City of Portland, Maine - Building or Use Permit Application

Permit No: 01-0440	Issue Date: MAY 16 2001	CBL: 413 B011001
-----------------------	----------------------------	---------------------

Location of Construction: 41 Copley Woods Circle lot 11	Owner Name: Kto Builders Inc	Owner Address: 588 Roosevelt Ter. Windham	Phone: 207-892-2021
Business Name: n/a	Contractor Name: KTO Builders	Contractor Address: 588 Roosevelt Ter. Windham	Phone: 2078927812
Lessee/Buyer's Name: n/a	Phone: n/a	Permit Type: Single Family	Zone: R-3 PRUD

Past Use: Vacant	Proposed Use: New Single Family approximately 46 x 37 (1700 sf)	Permit Fee: \$444.00	Cost of Work: \$70,000.00	CEO District: 2
Proposed Project Description: New Single Family		FIRE DEPT: <input type="checkbox"/> Approved <input type="checkbox"/> Denied	INSPECTION: Use Group: R-3 Type: 5B 300299/REMENTS PERMIT ISSUED WITH REQUIREMENTS

**FIRST & SECOND FLOOR PLAN**  
**LOT #11**  
**CAMPBELL RESIDENCE**

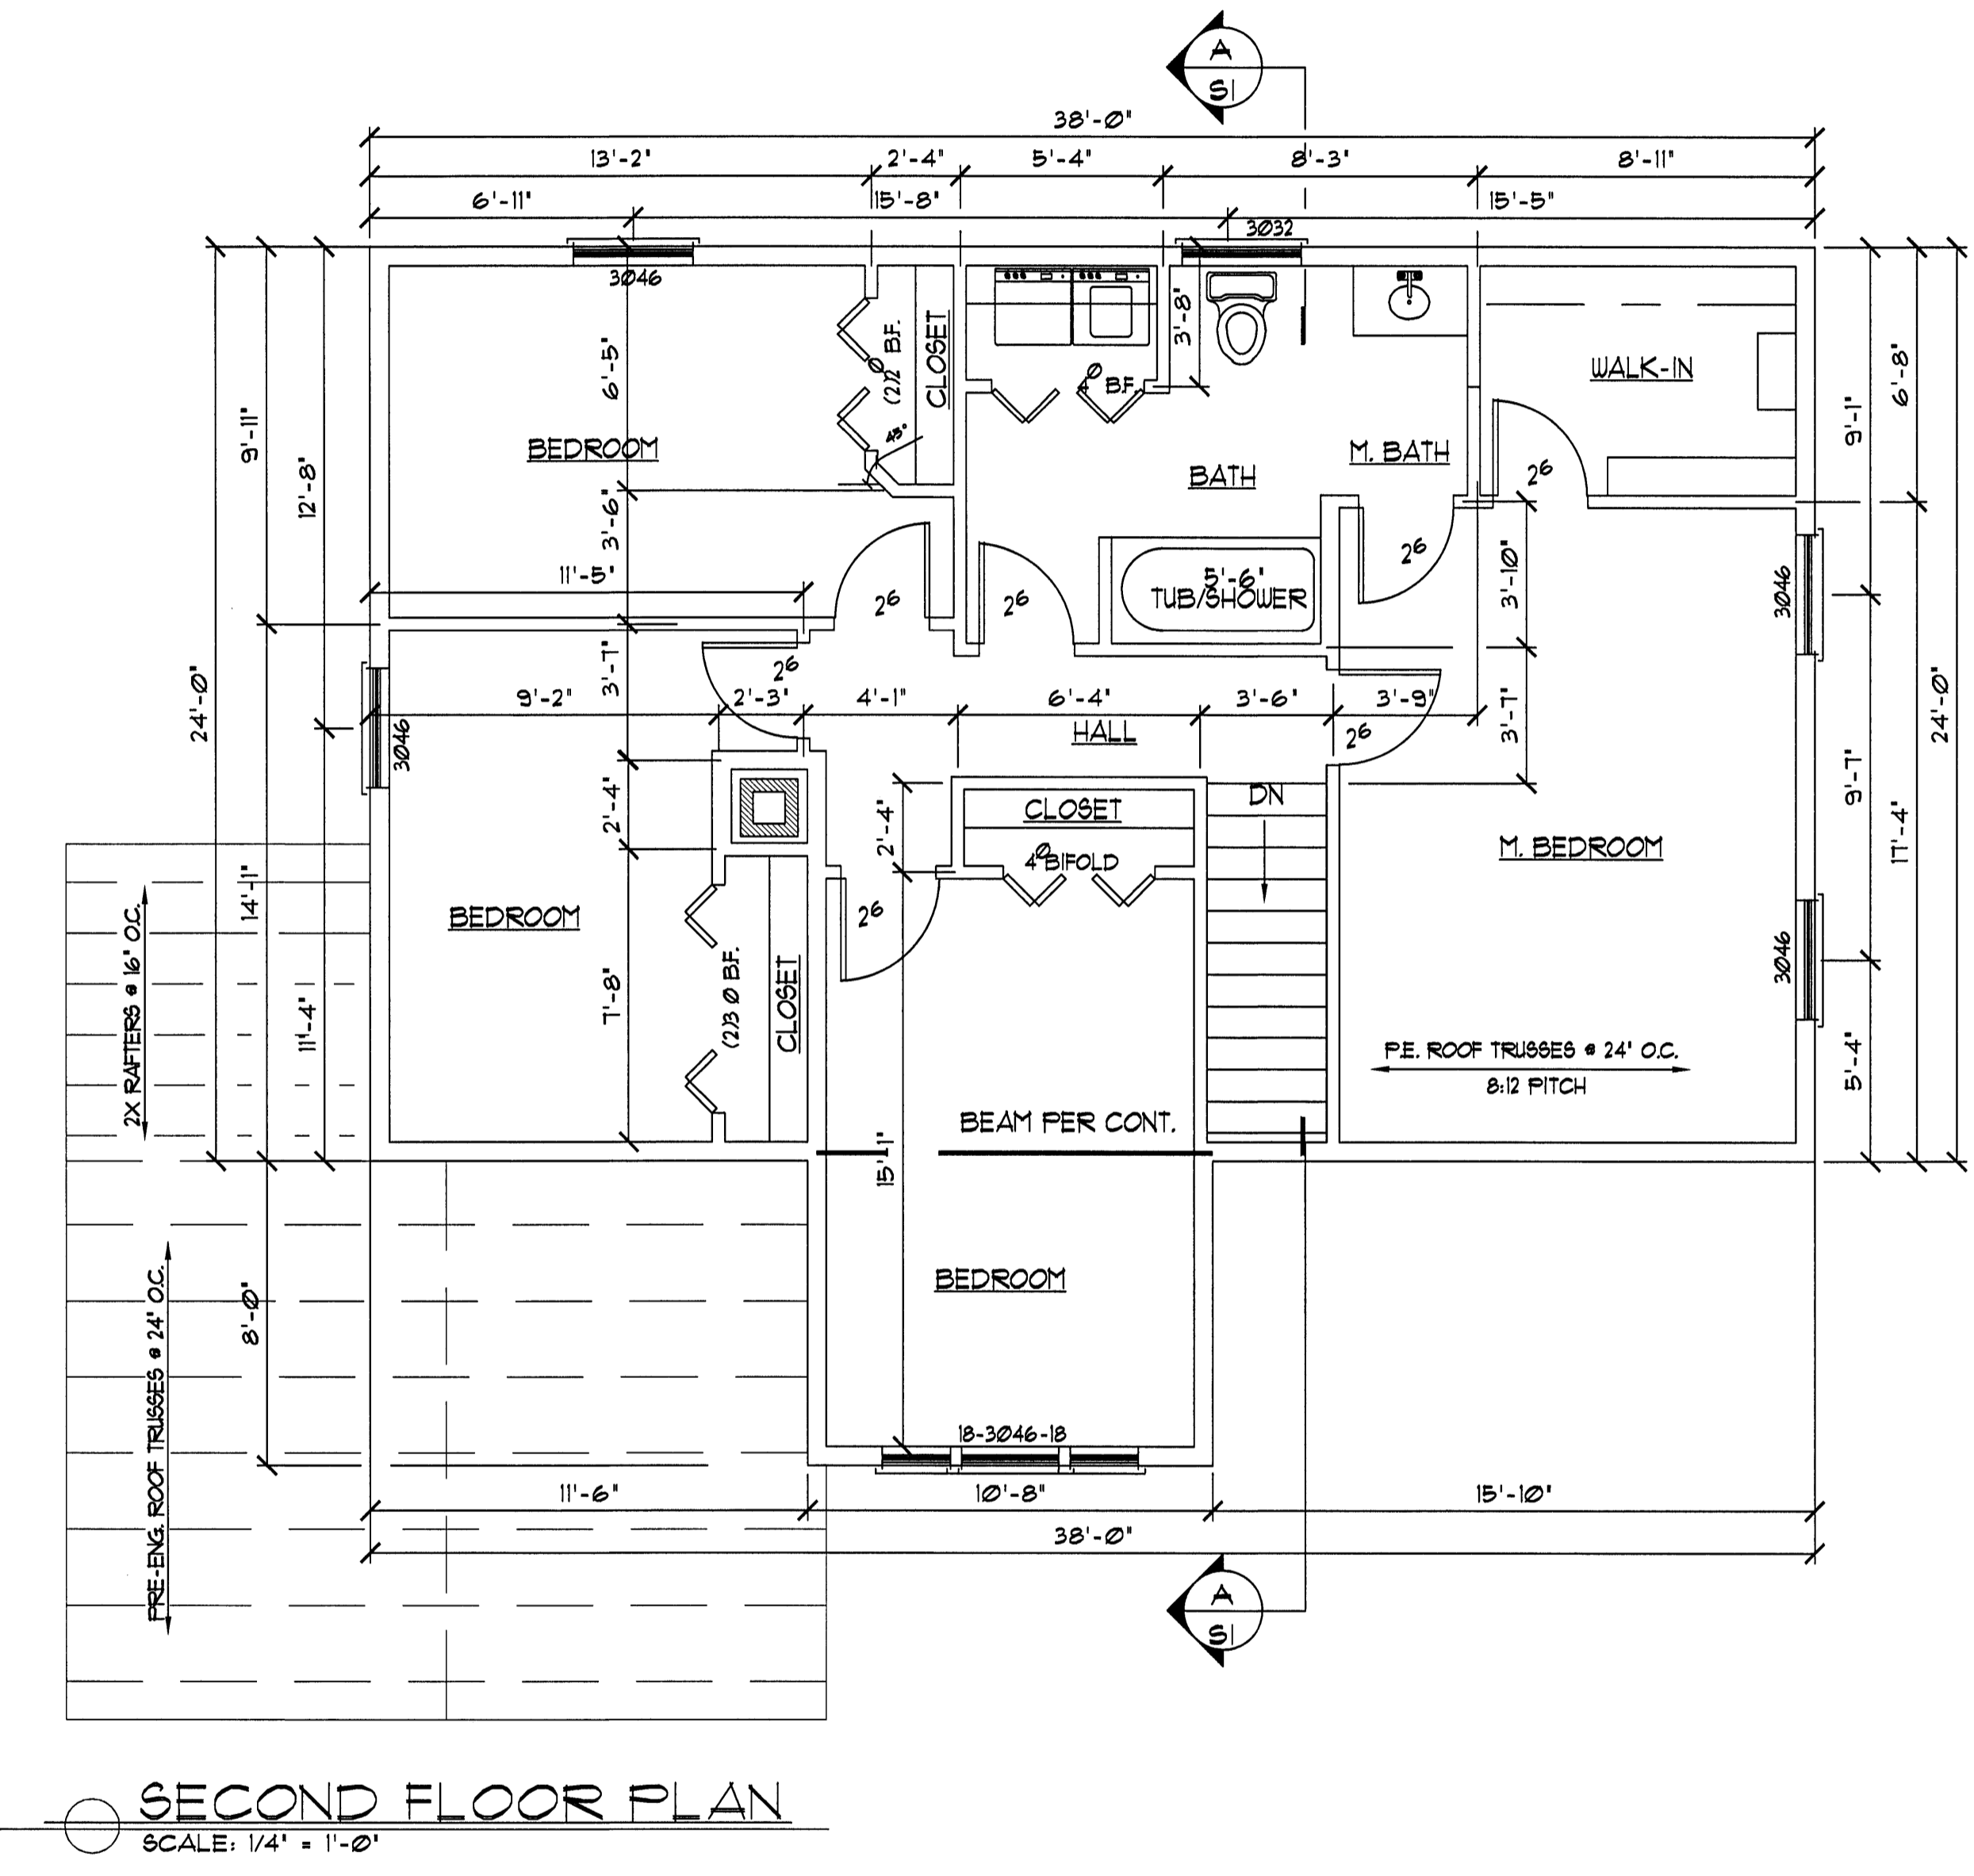
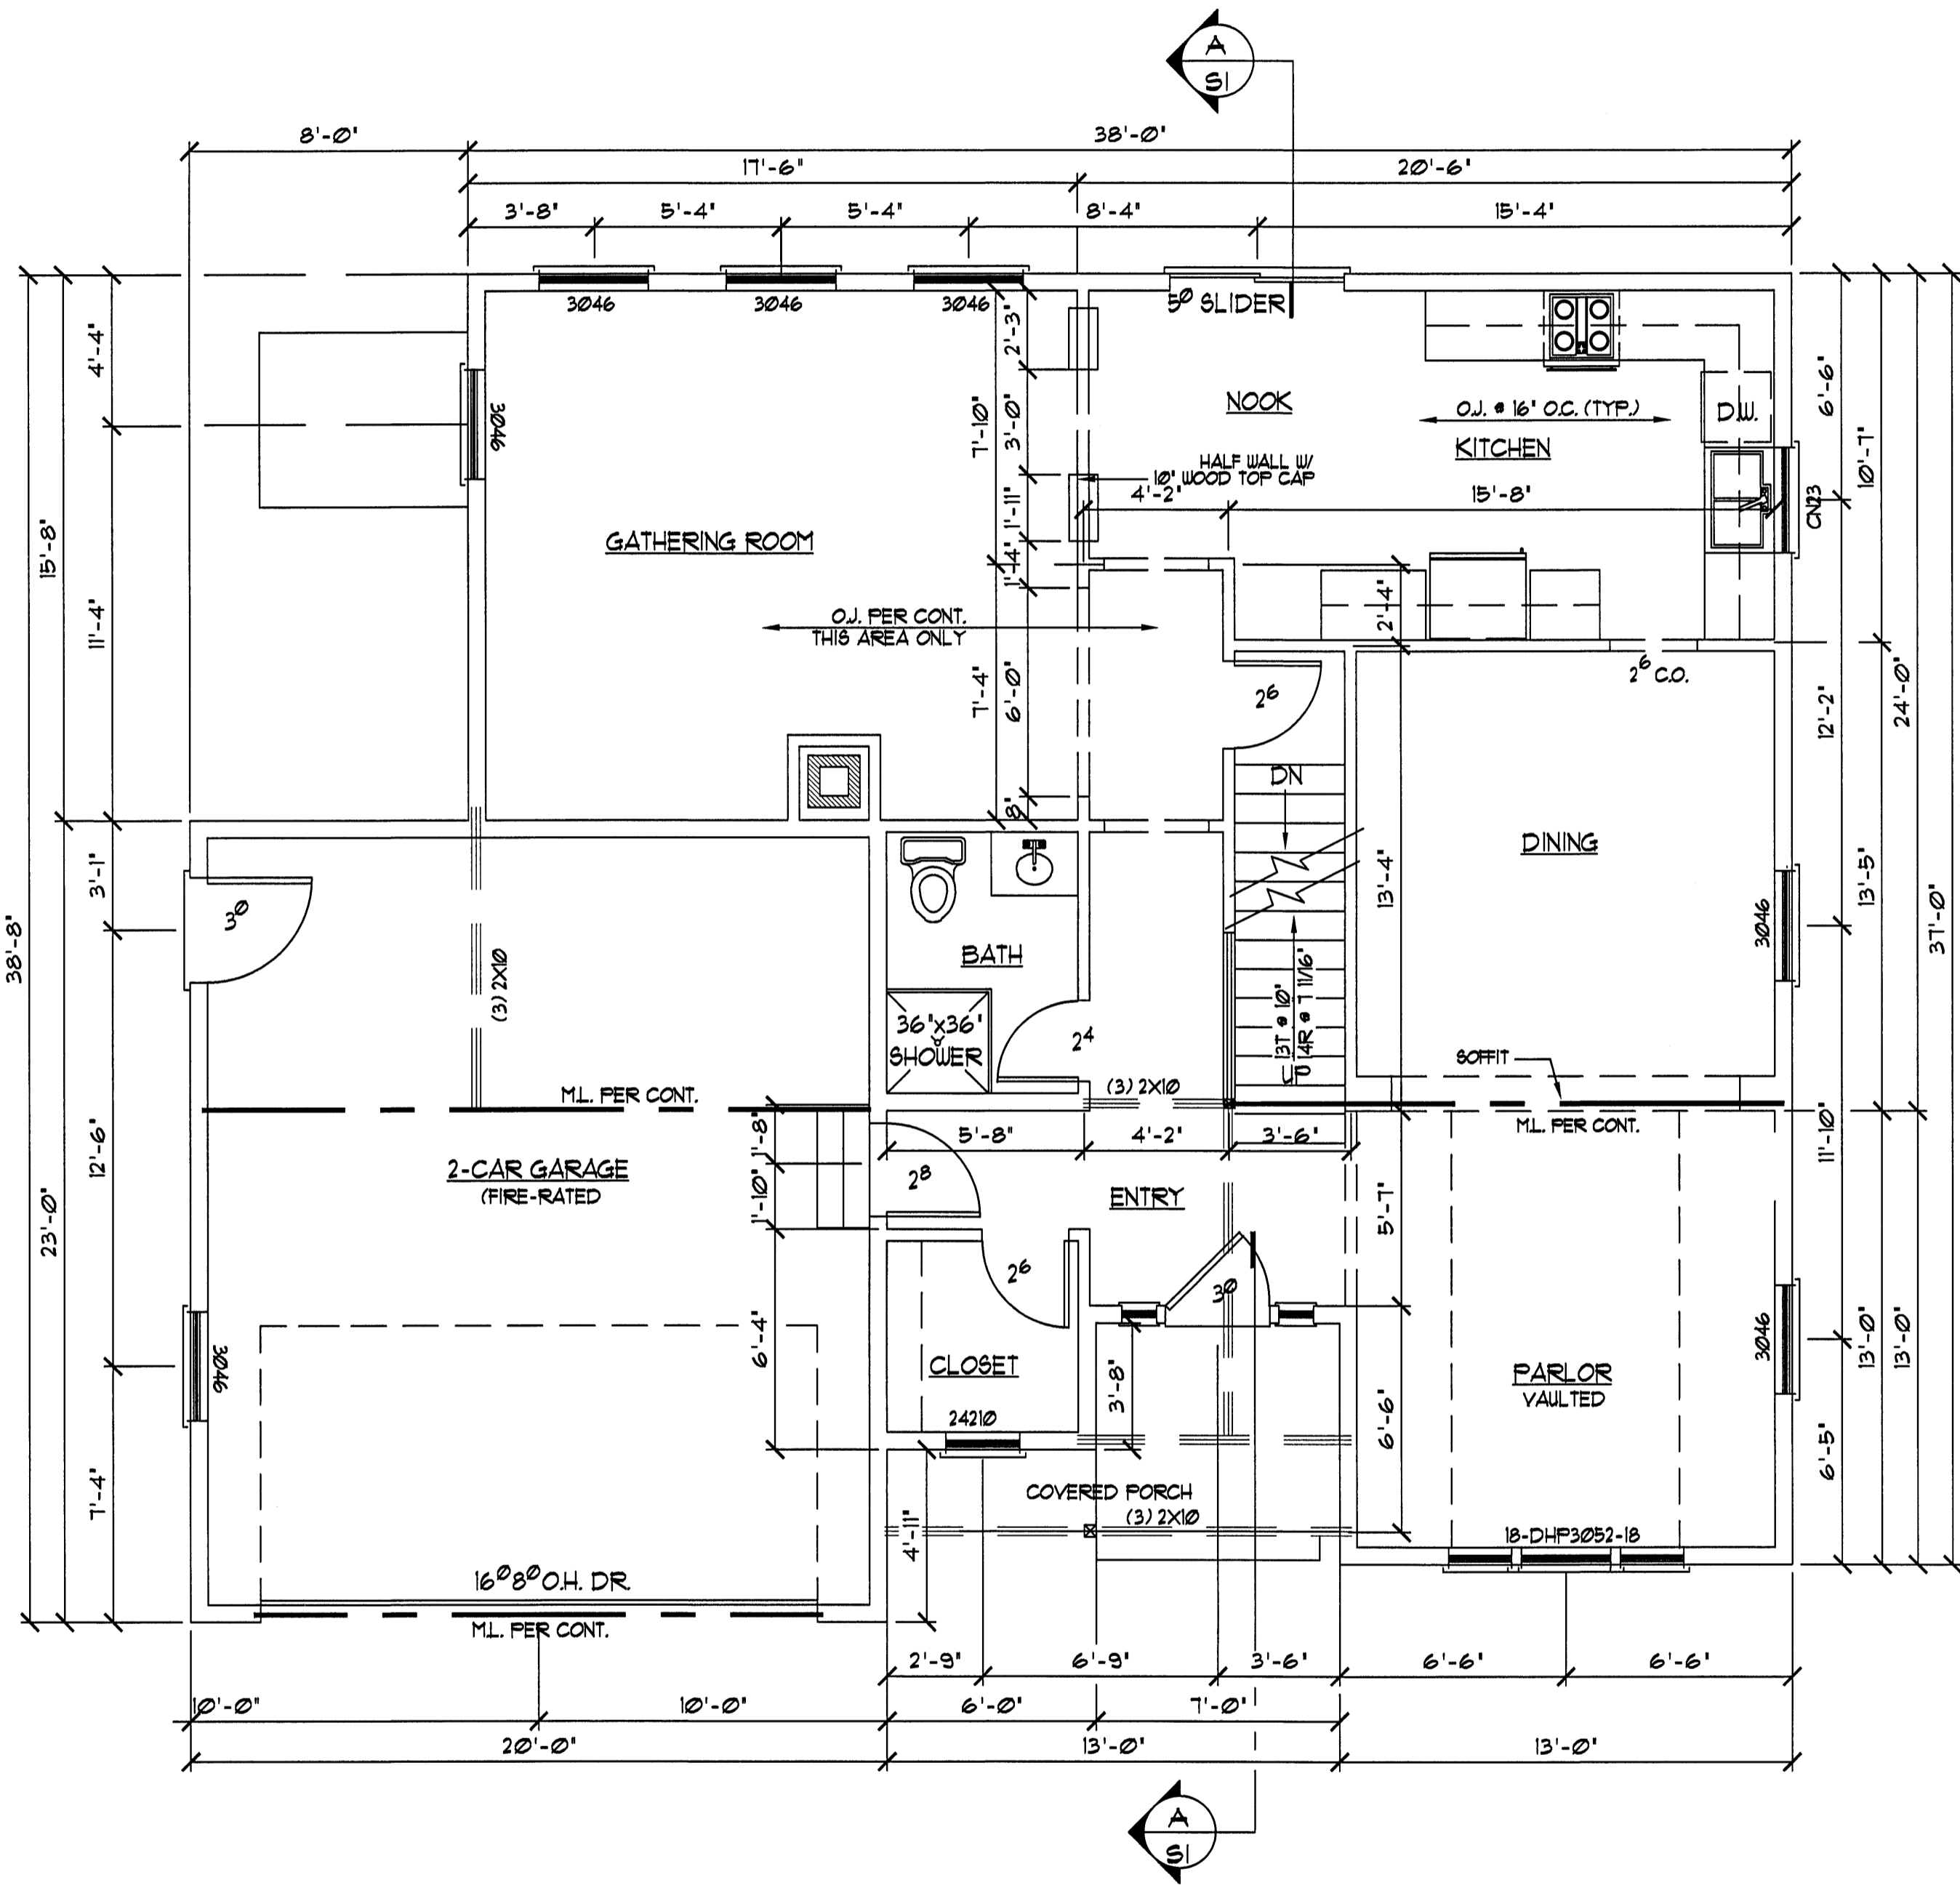
6-5-01: 2nd fl. Egress window 23 1/2" H x 16" W, Broken
steel @ Entry closet, elect boxes W/I 2' @
garage wall. No W/A

Seal SR at corner in garage 2nd floor

Add SR two more Rafter Bays - Garage

Rail in garage steps

6-20-01: Egress window measure 24 1/4" x 33 1/2"
elect boxes moved off garage wall

**FOUNDATION PLAN**  
**LOT #11**  
**CAMPBELL RESIDENCE**

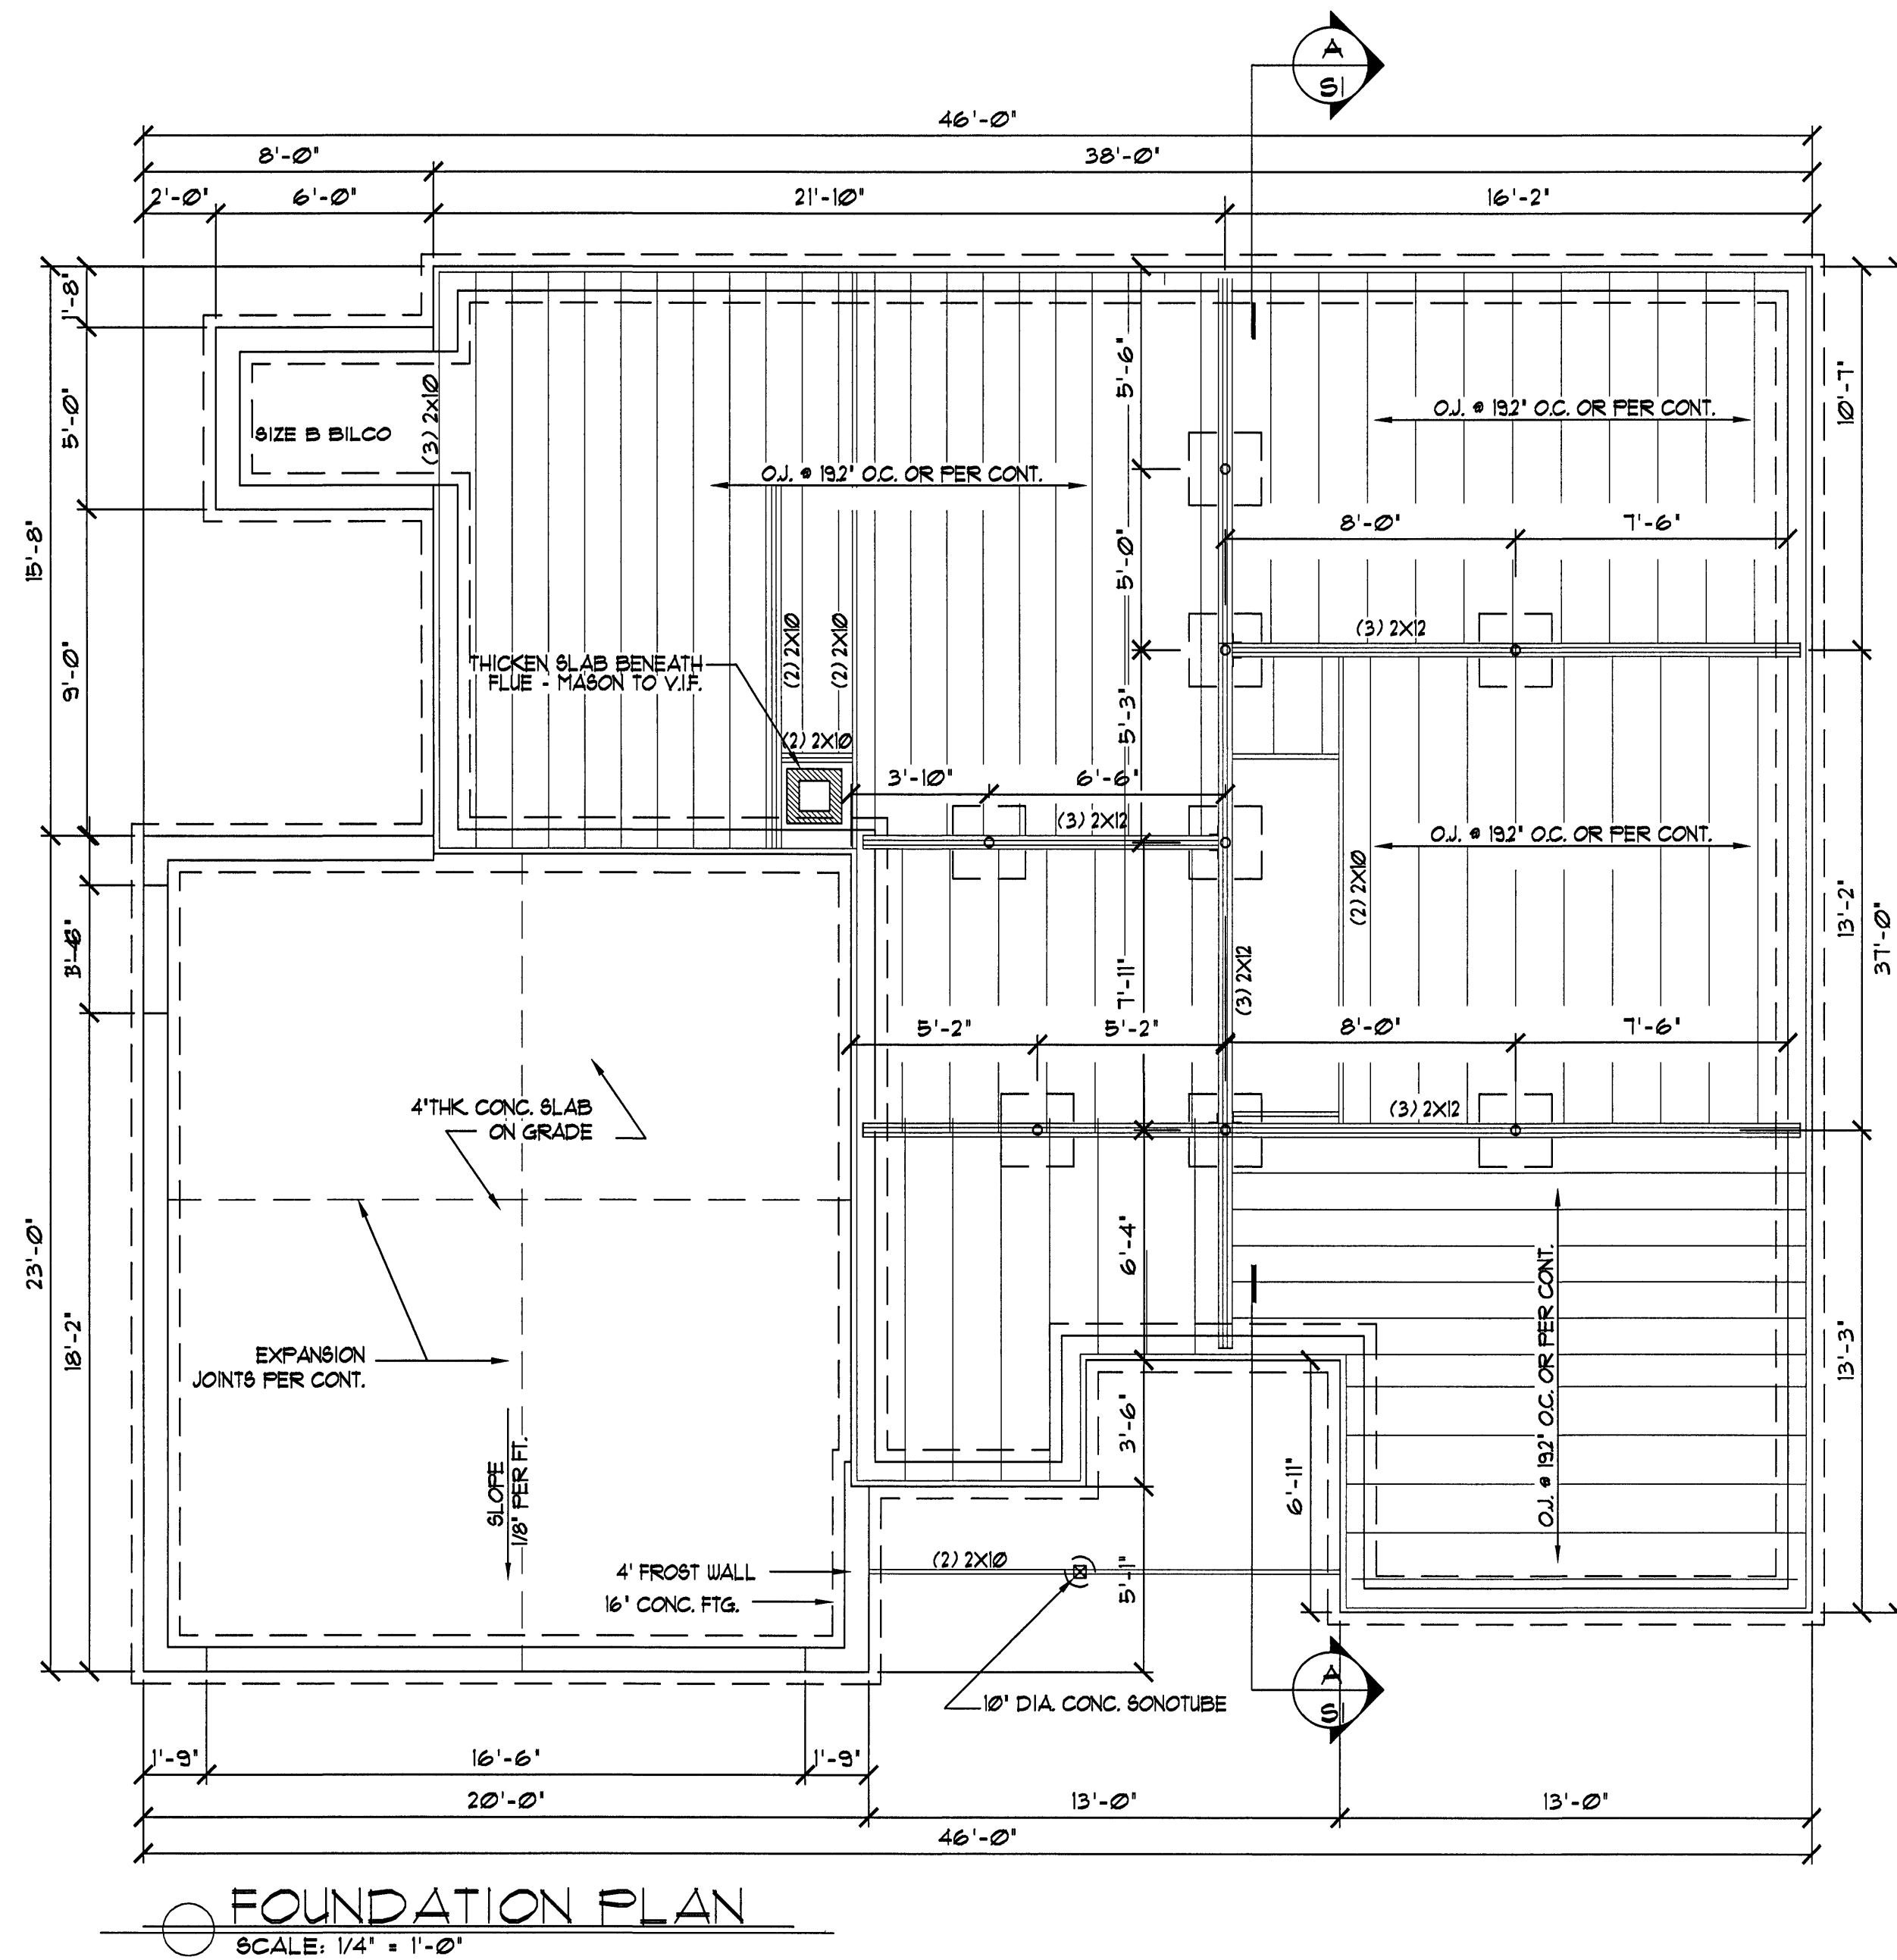
Lally 9'9" 3-2x12
Needs Lally support

15'3" 3-2x12 NO Lally support
need lally at 7'10" Beam
